FAREHAM

BOROUGH COUNCIL

**Fareham Borough Council - Relevant Representation
Hampshire Water Transfer and Water Recycling Plant Development Consent Order
Application by Southern Water Services Limited**

PROJECT TITLE
 Hampshire Water Transfer and Water Recycling Project

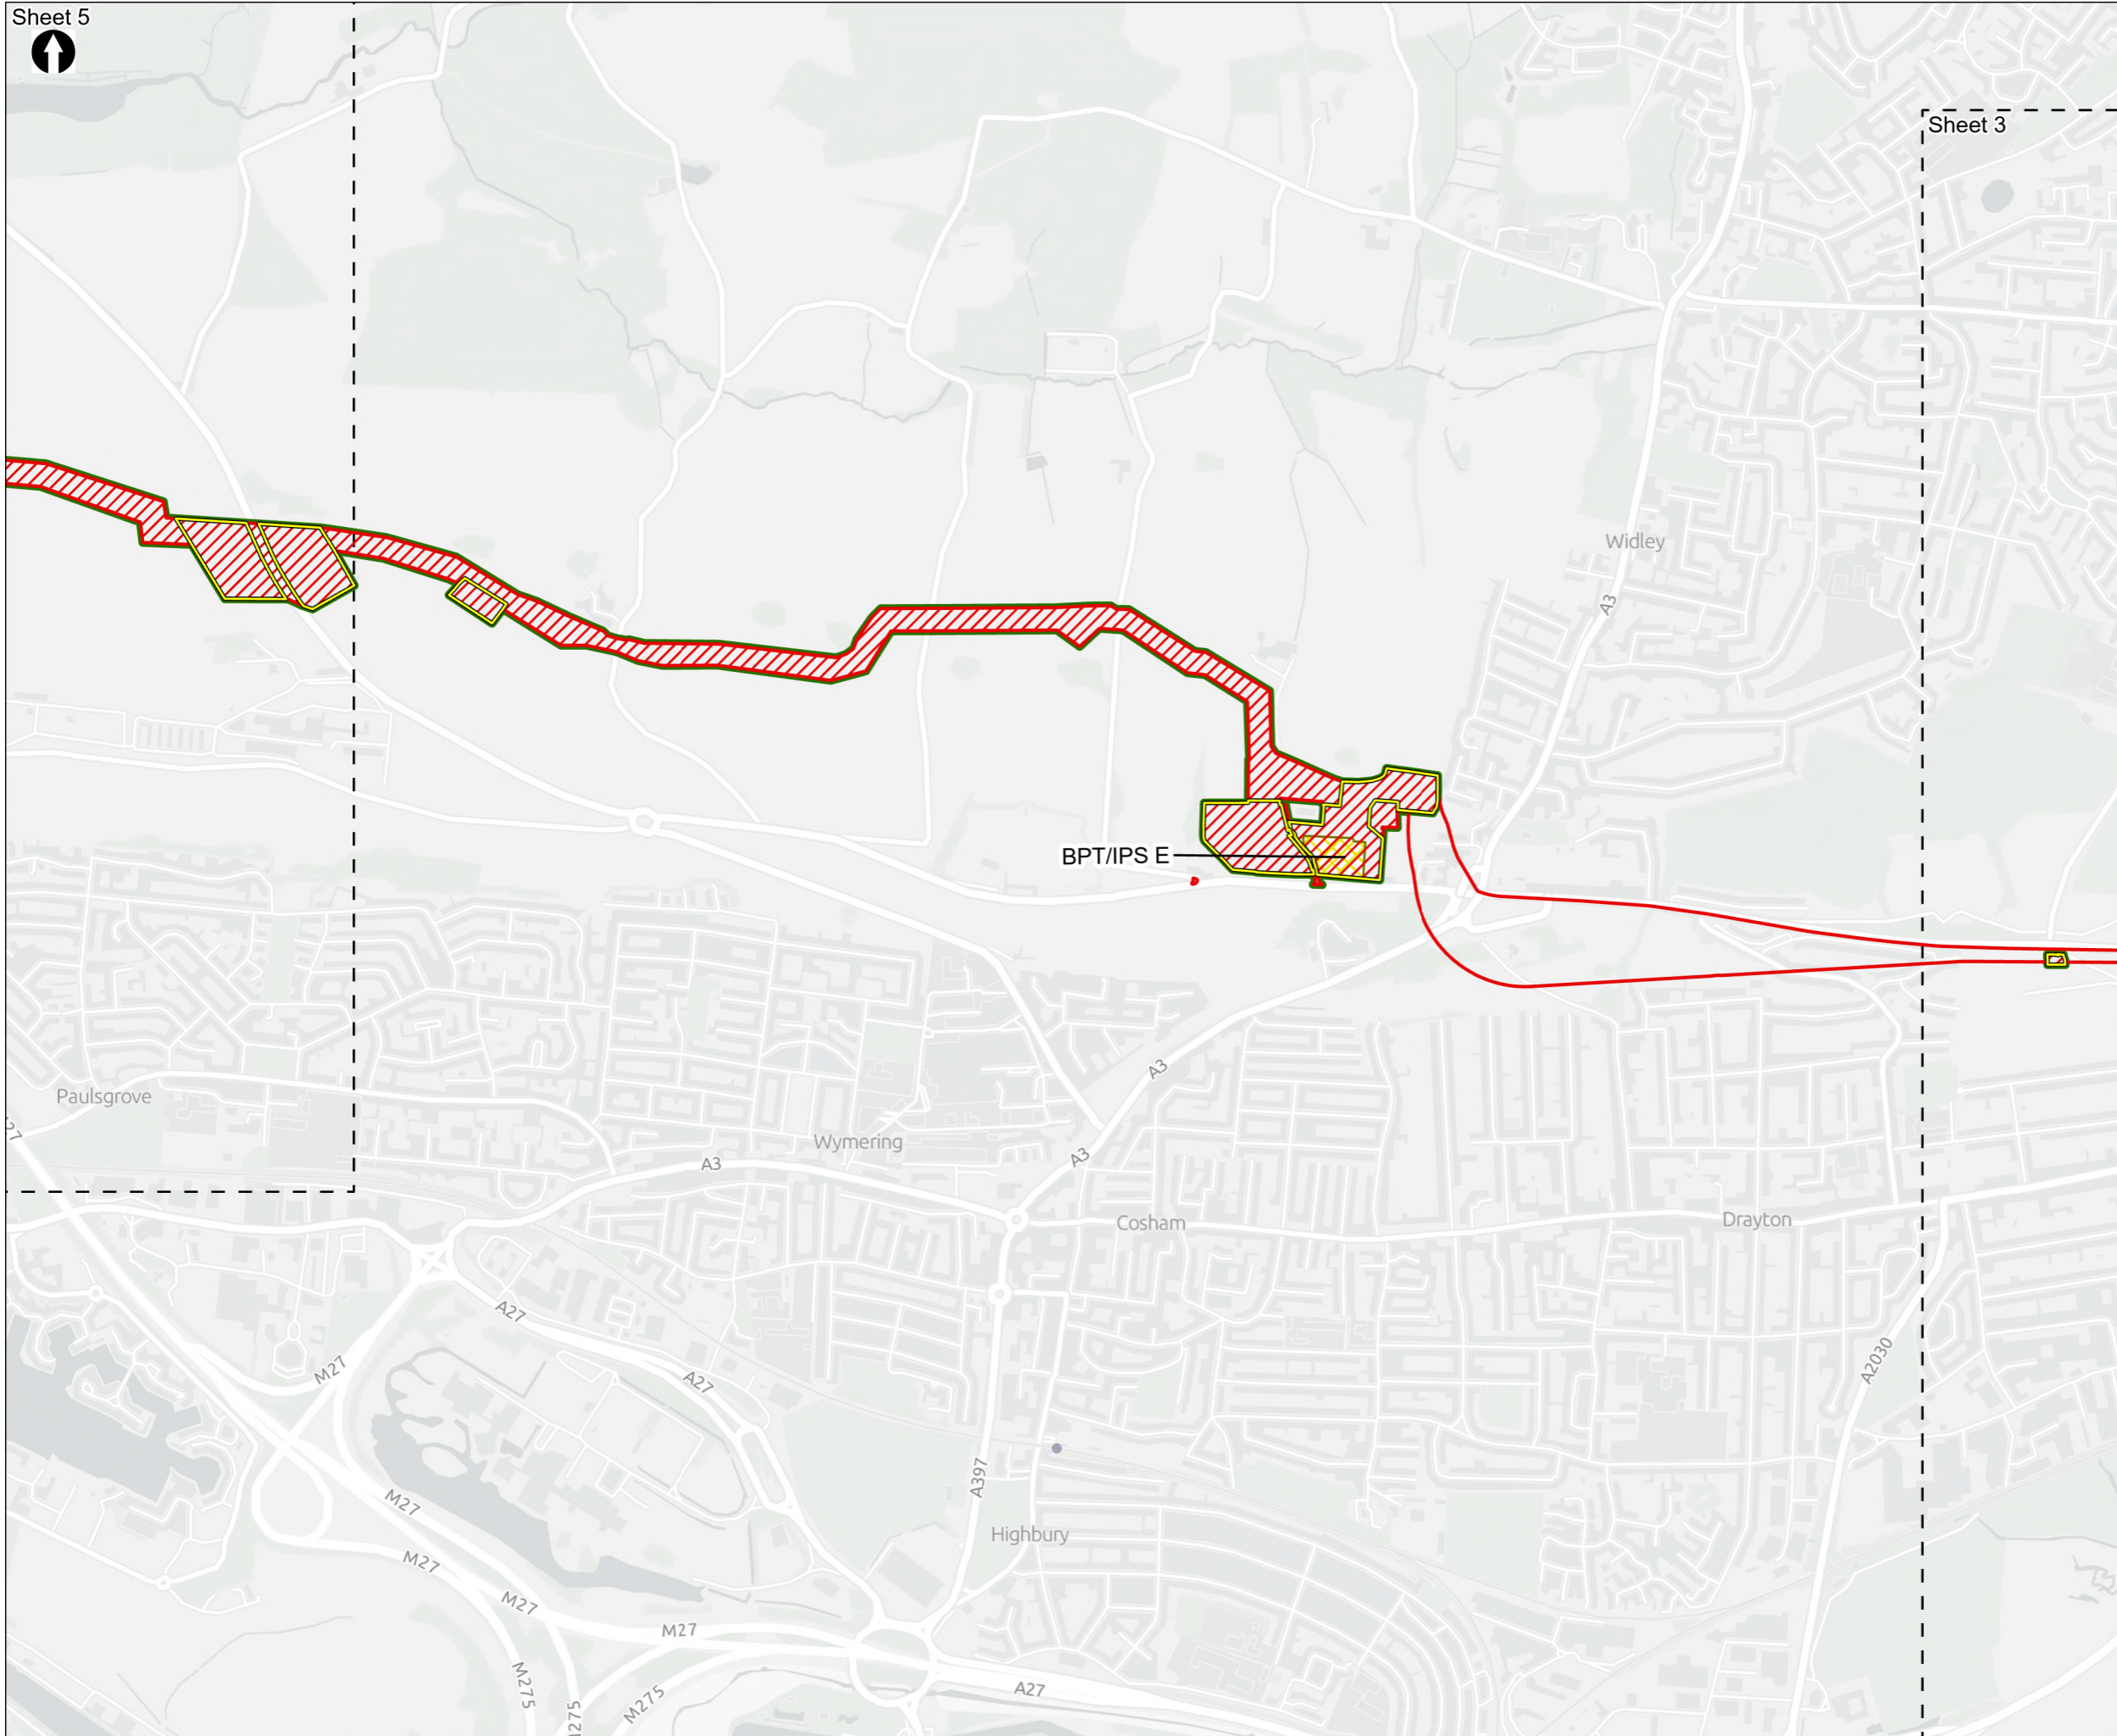
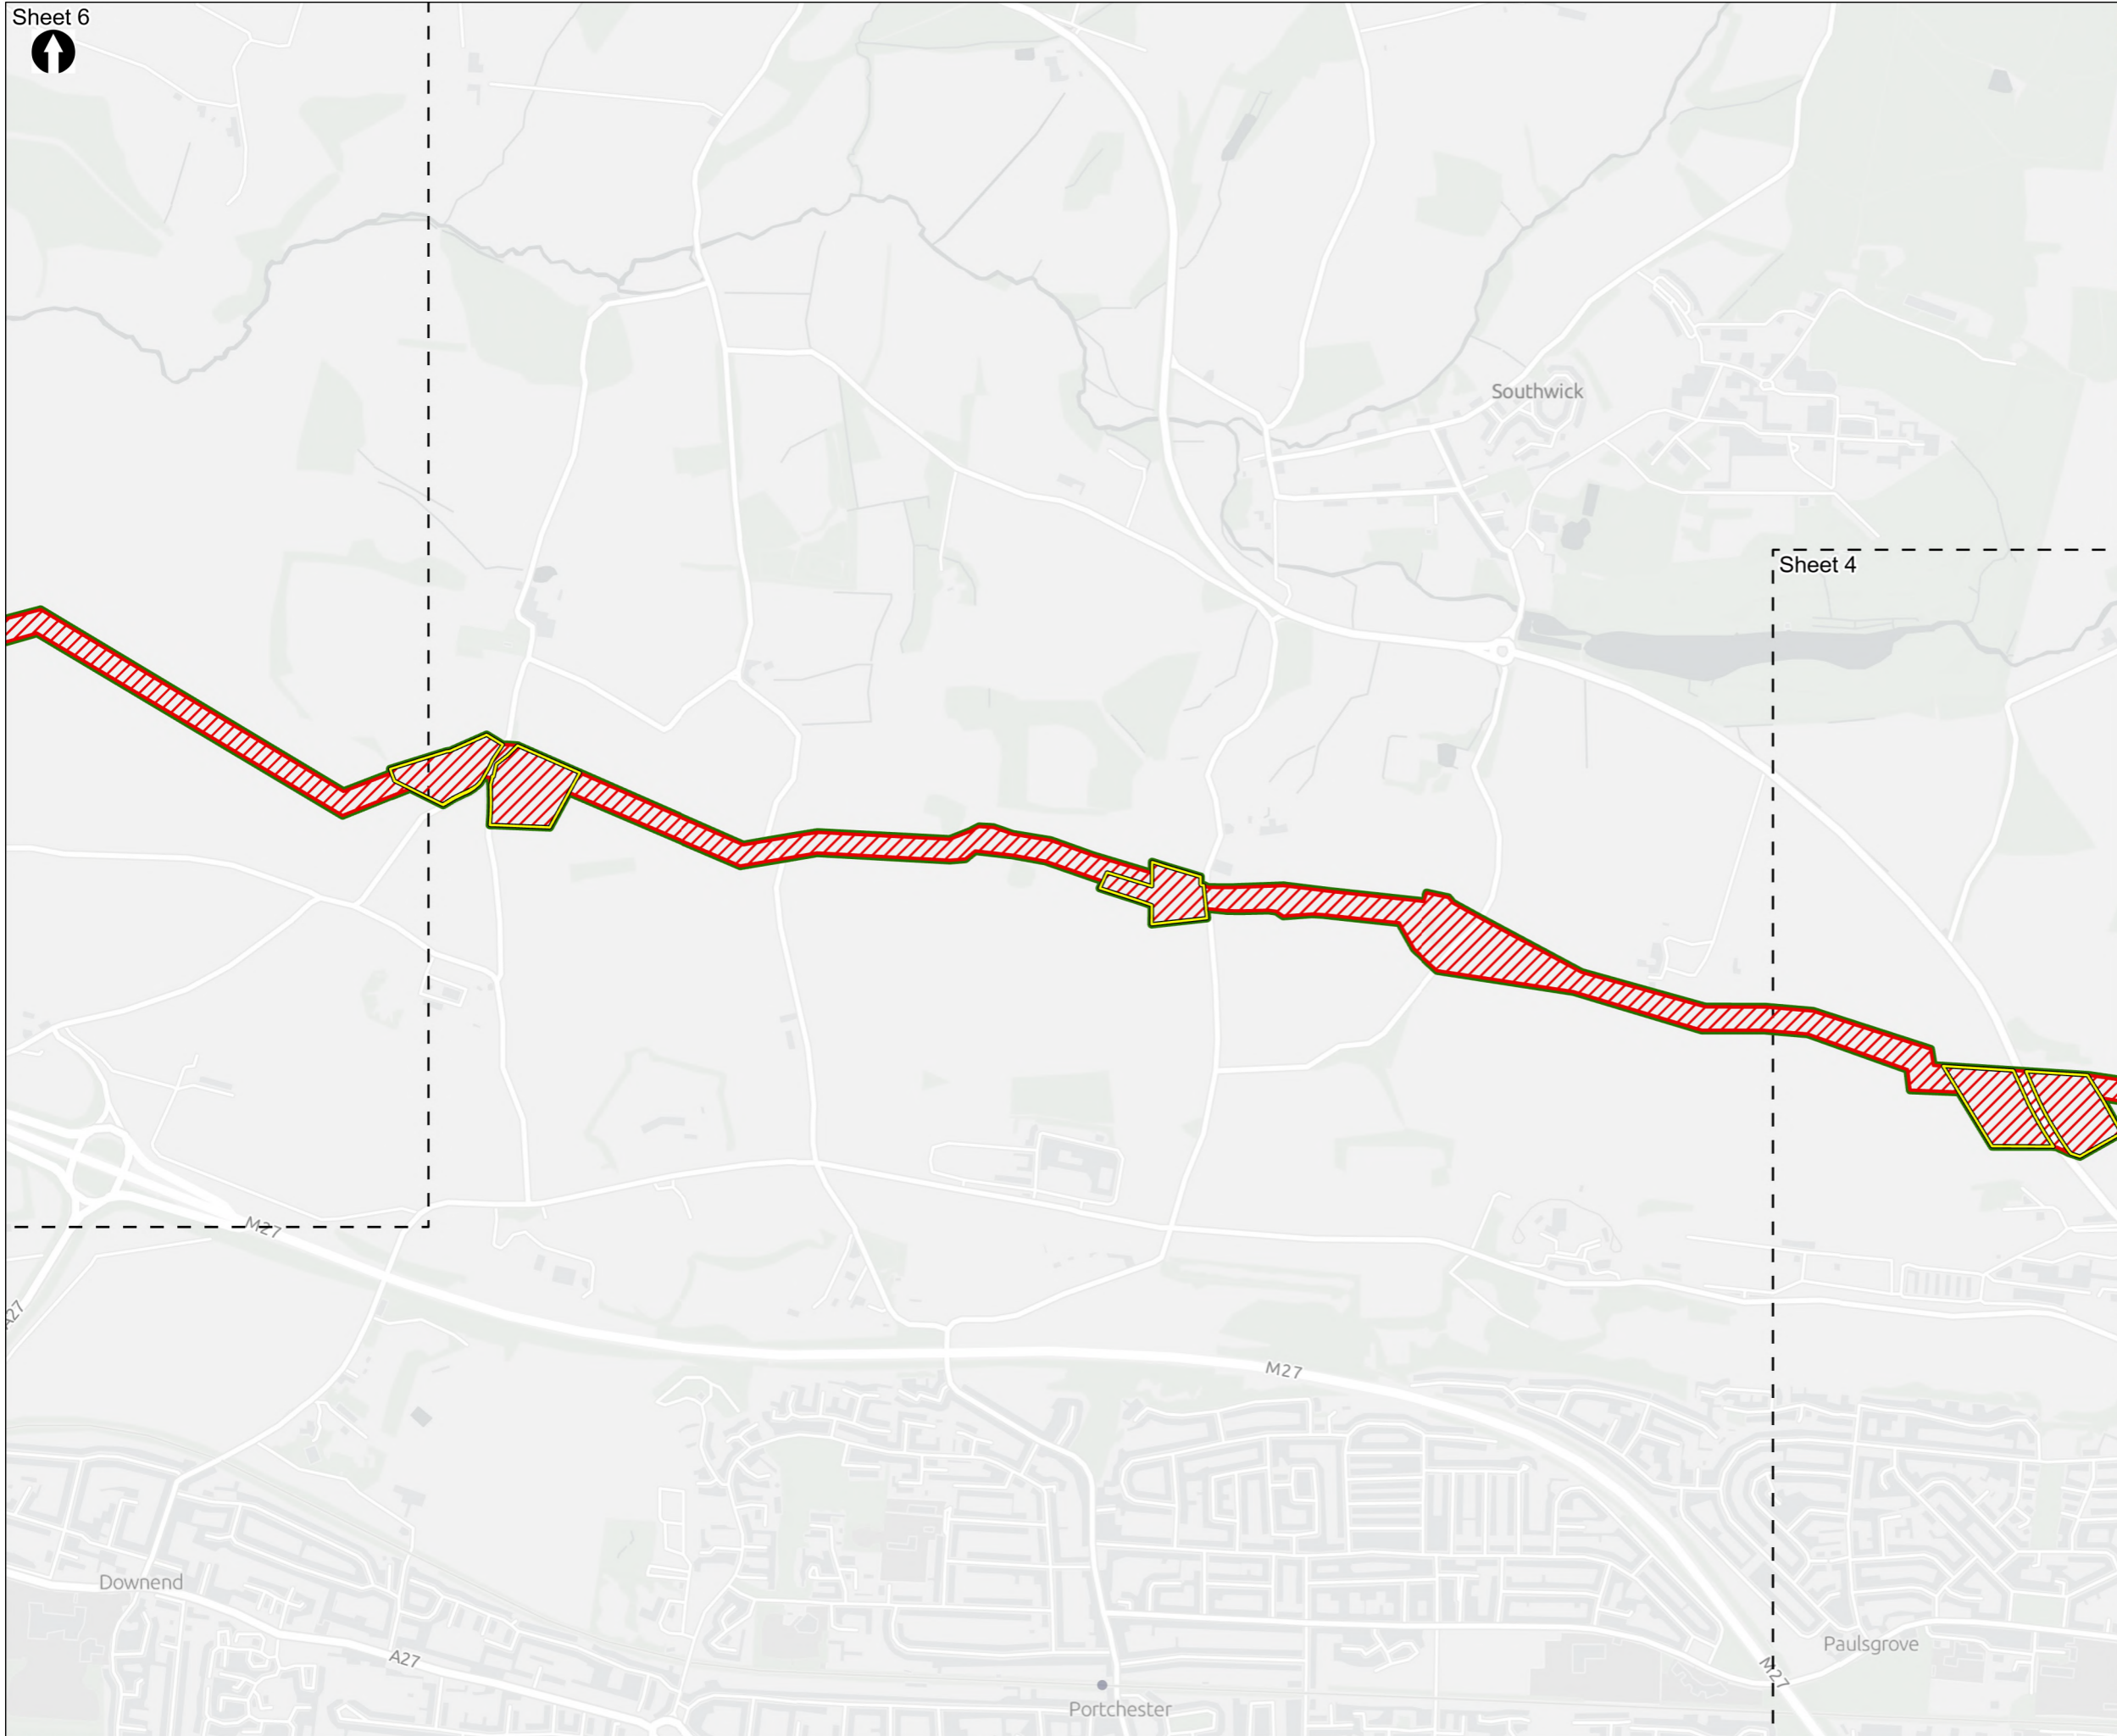
Whilst there will be a 15m buffer between Carpenters Copse Ancient Woodland/SINC and the works, there will be medium-term severance of the woodland/hedgerow network connected to this Ancient Woodland in areas shown below in yellow. Therefore, FBC is not clear why the modelling and survey work (statics and nighttime bat walkovers) did not cover this area, as a sampling location and key connective location, for the presence of bats, particularly Annex II bat *Barbastelle*. Instead, a static was placed at the crossing with the River Wallington, where the impact is limited due to the trenchless nature of the crossing. Given the large number of Ancient Woodlands located to the east, west and north of Carpenters Copse, it is not considered that sufficient survey work has been carried out to understand the baseline and enable impact assessment/proportionate mitigation in the areas to be affected as a result of severance of commuting routes for bat populations.
